MEMORANDUM

Subject: Application ID: 2017-289

Date: 2/21/2018

[ East Towers ] Logistics Plans and Studies

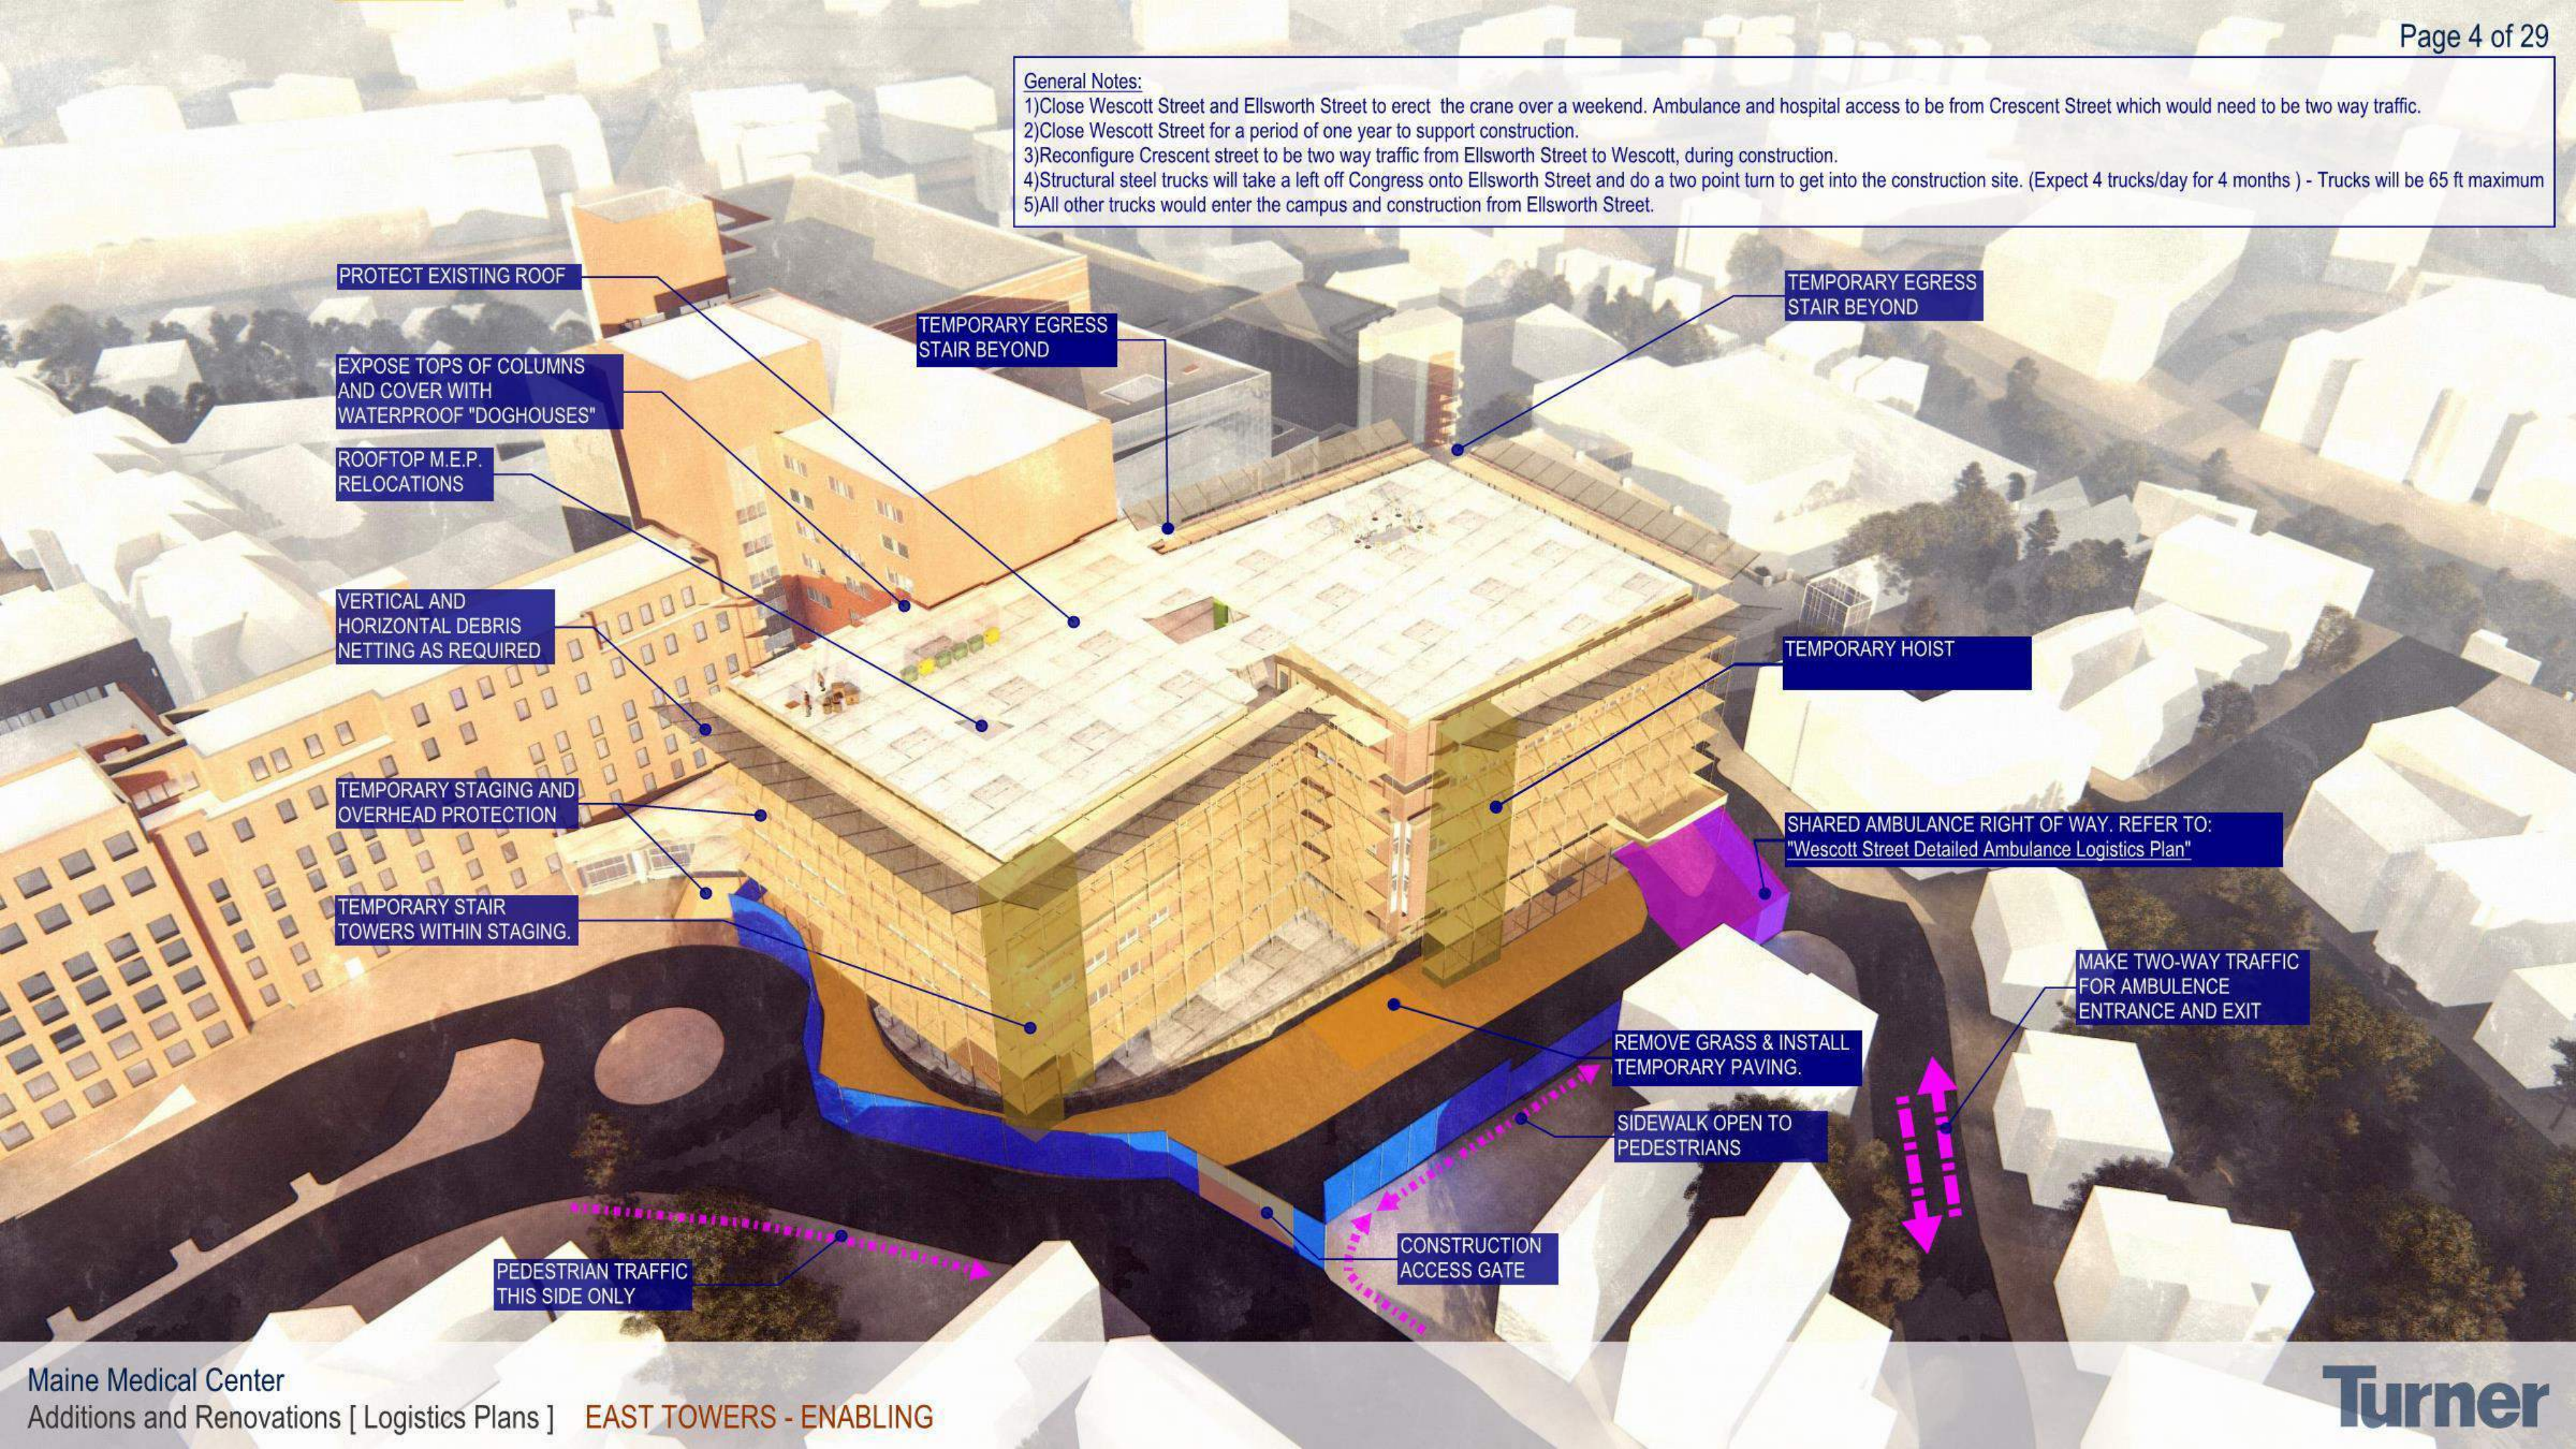
Circulation--The ambulance emergency room entrance should remain open to one way traffic. The area can be difficult to maneuver in its current design. Making the patient delivery area a two way drop off doesn't seem achievable.

2/21/2018 The plan has been changed to accommodate one way traffic through the ambulance bay at MMC. Some additional landscaping will be done to allow the ambulance approach from Crescent Street. An alternative ambulance route for ambulances will be via Gilman Street.

[ Visitors Garage ] Logistics Plans and Studies

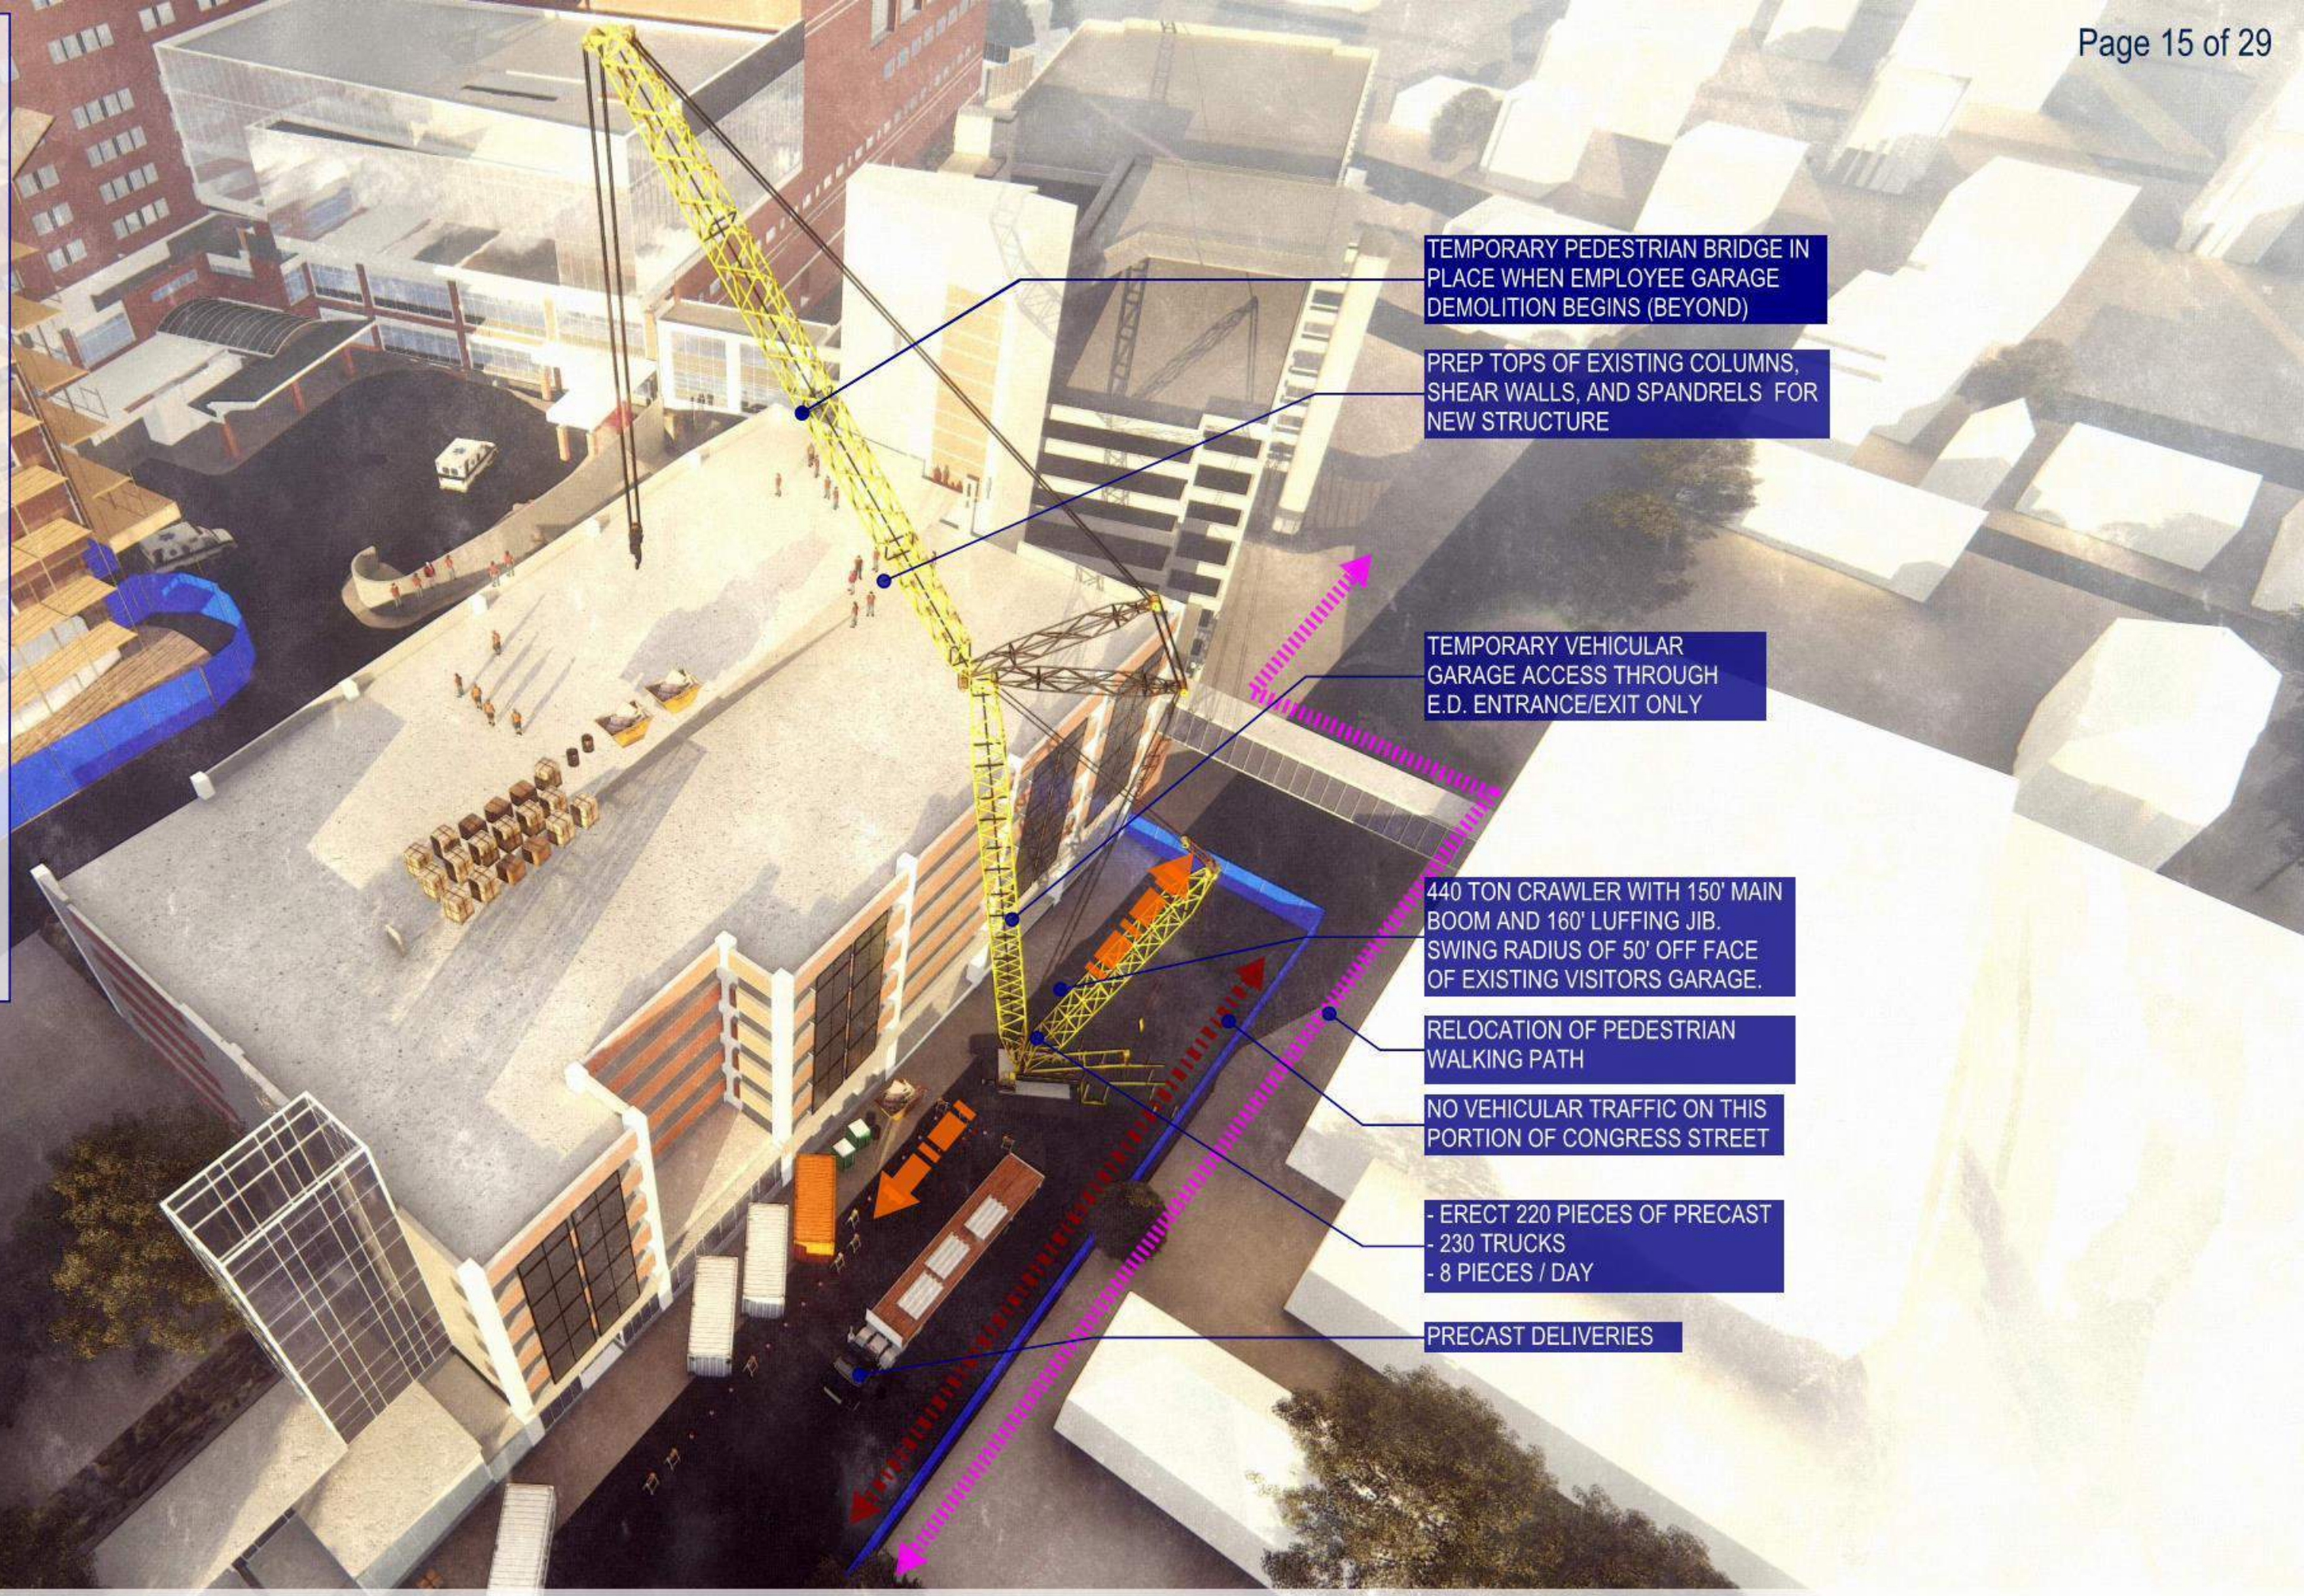
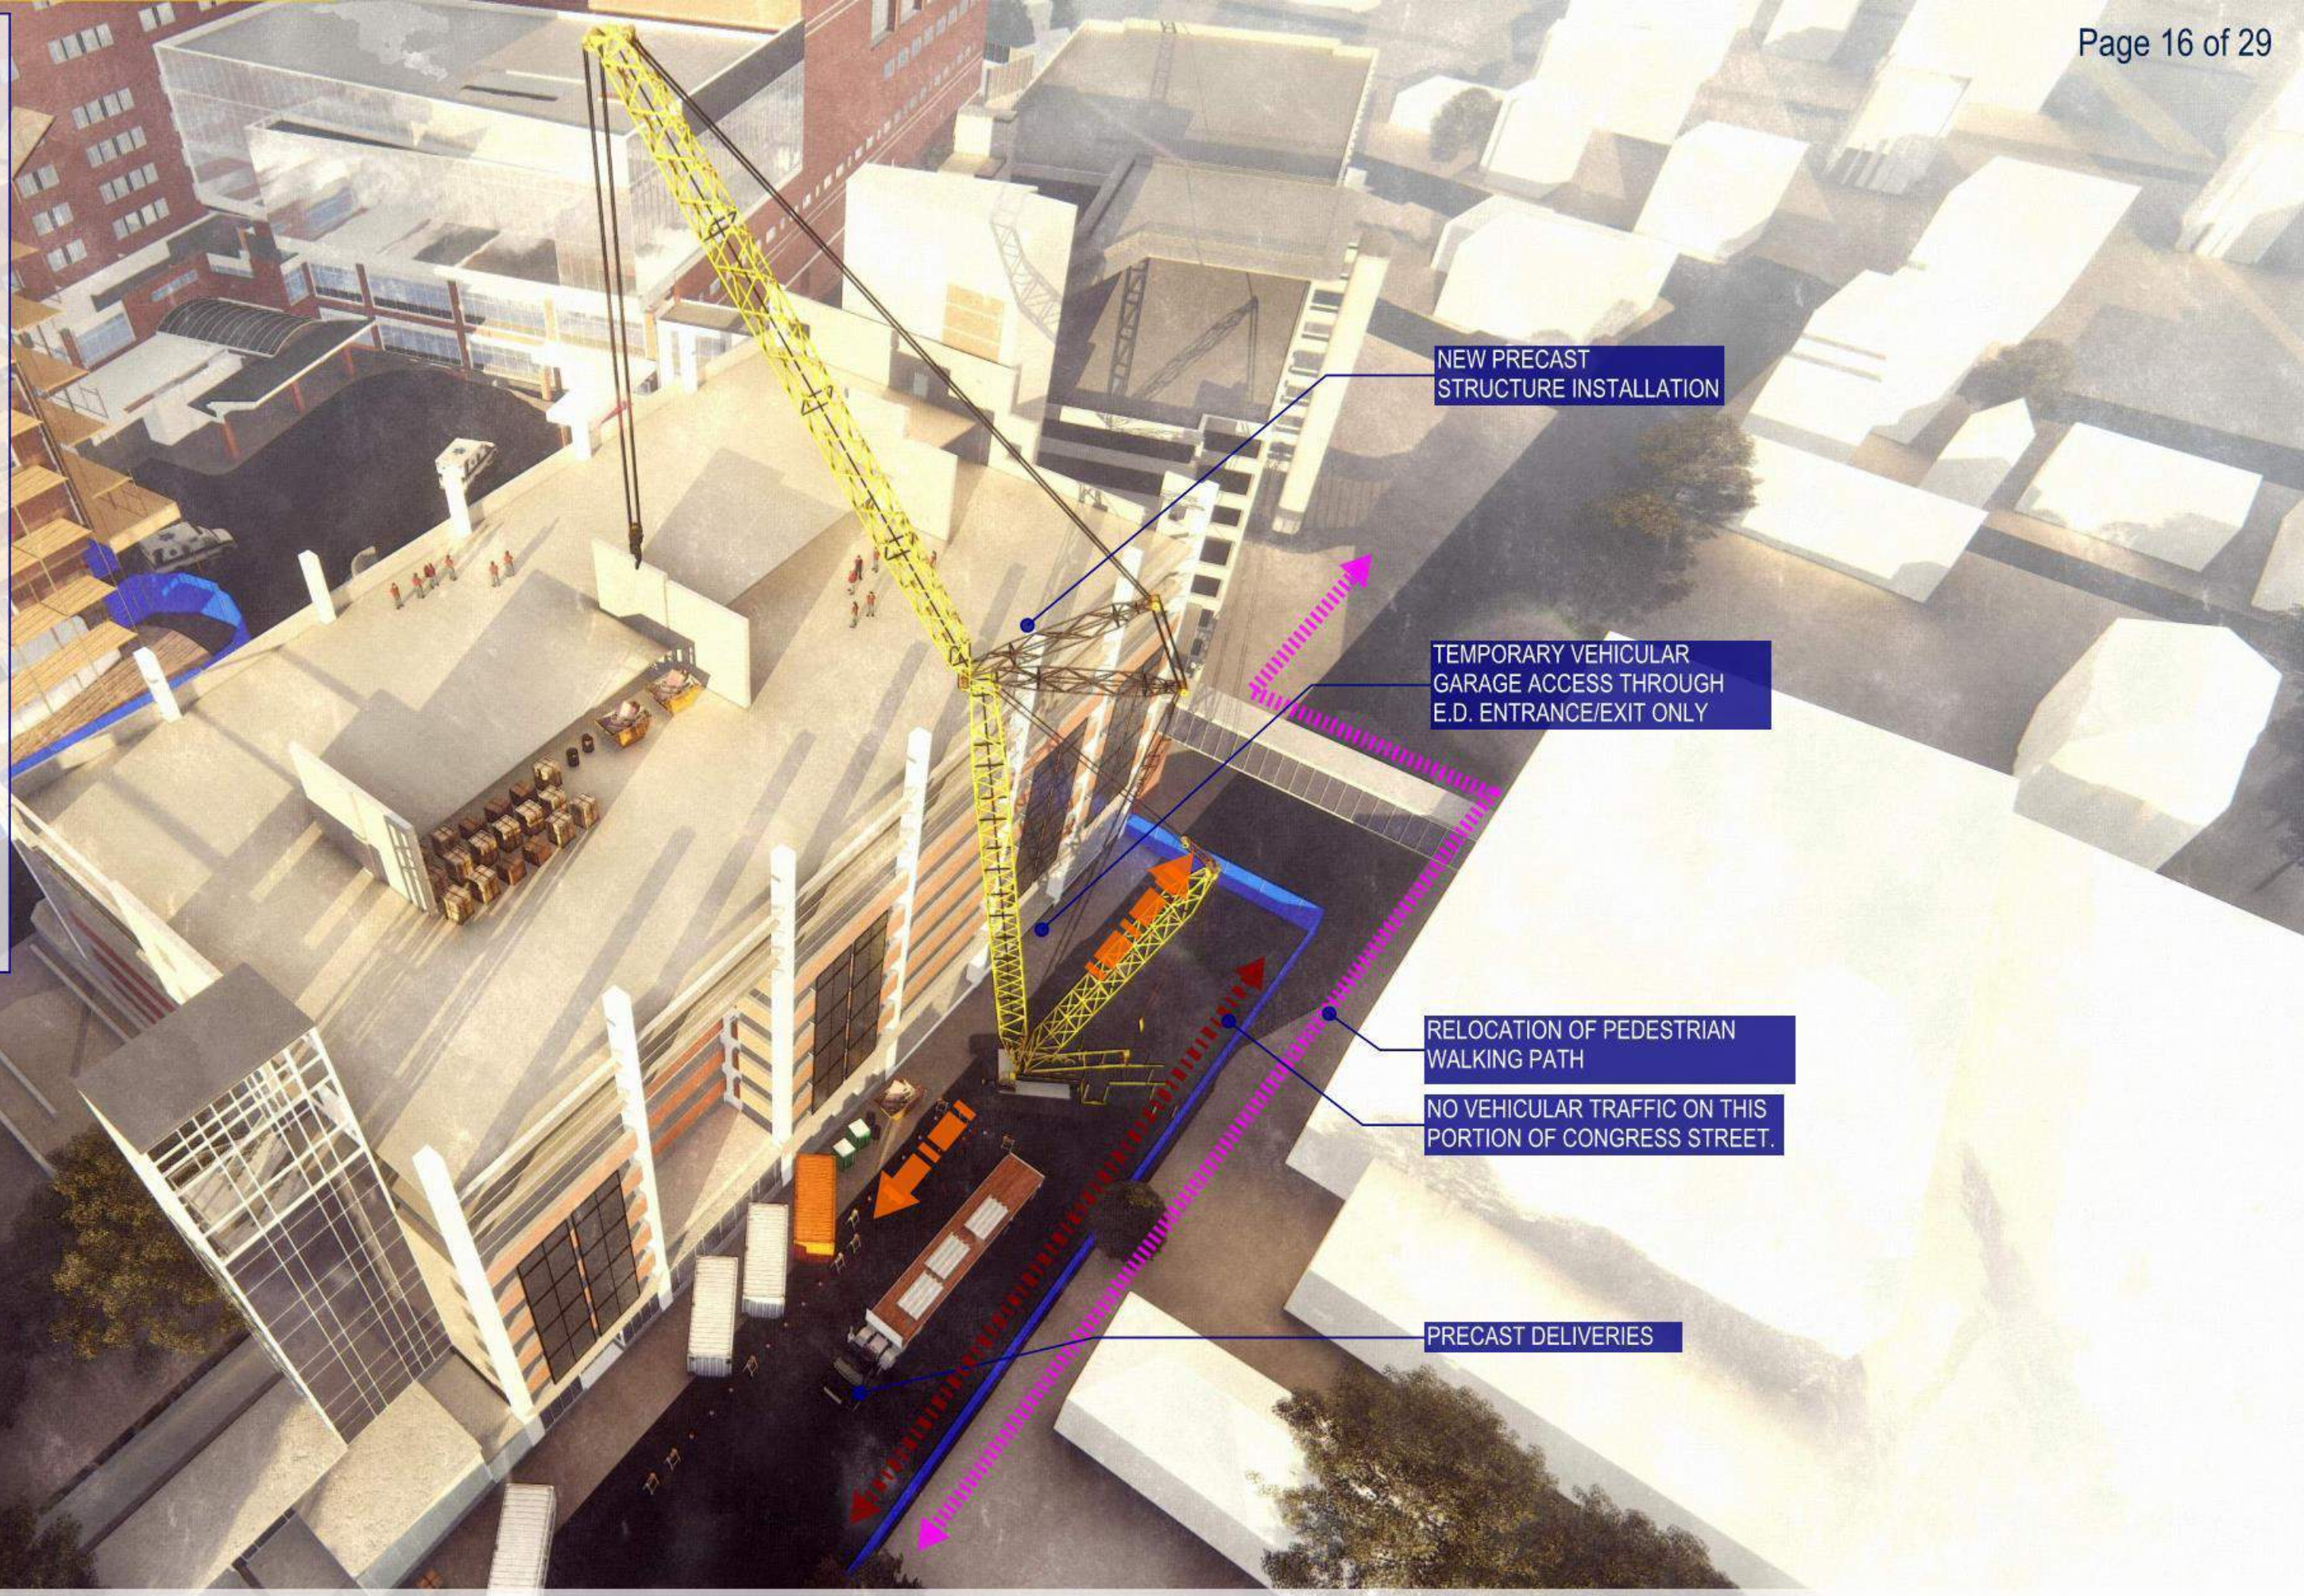
1/17/2018

2/21/2018 Congress Street will be closed for several weeks. Ambulances destined for the hospital will follow the same detour as other traffic. Fire apparatus responding from the peninsula will make route adjustments when responding West of Deering Avenue.
